# Site Plan

**From:** Tammy Dale <chattvolunteer@yahoo.com>  
**Sent:** Wednesday, June 26, 2019 11:38 AM  
**To:** Judith Espinoza  
**Subject:** Re: AG Structure Exemption

Planning and Community Development Department - SITE PLAN

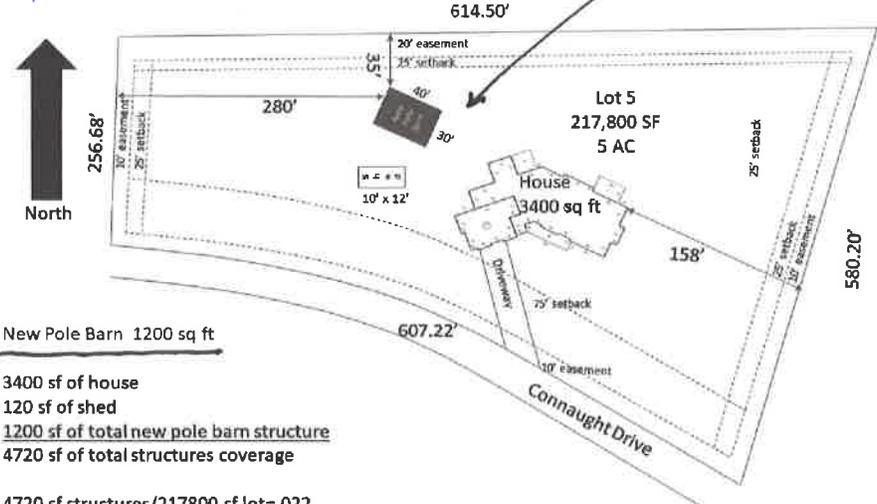
Your enclosed site plan looks good. I just need to edit the lot coverage as it does not included footprint of your main dwelling.
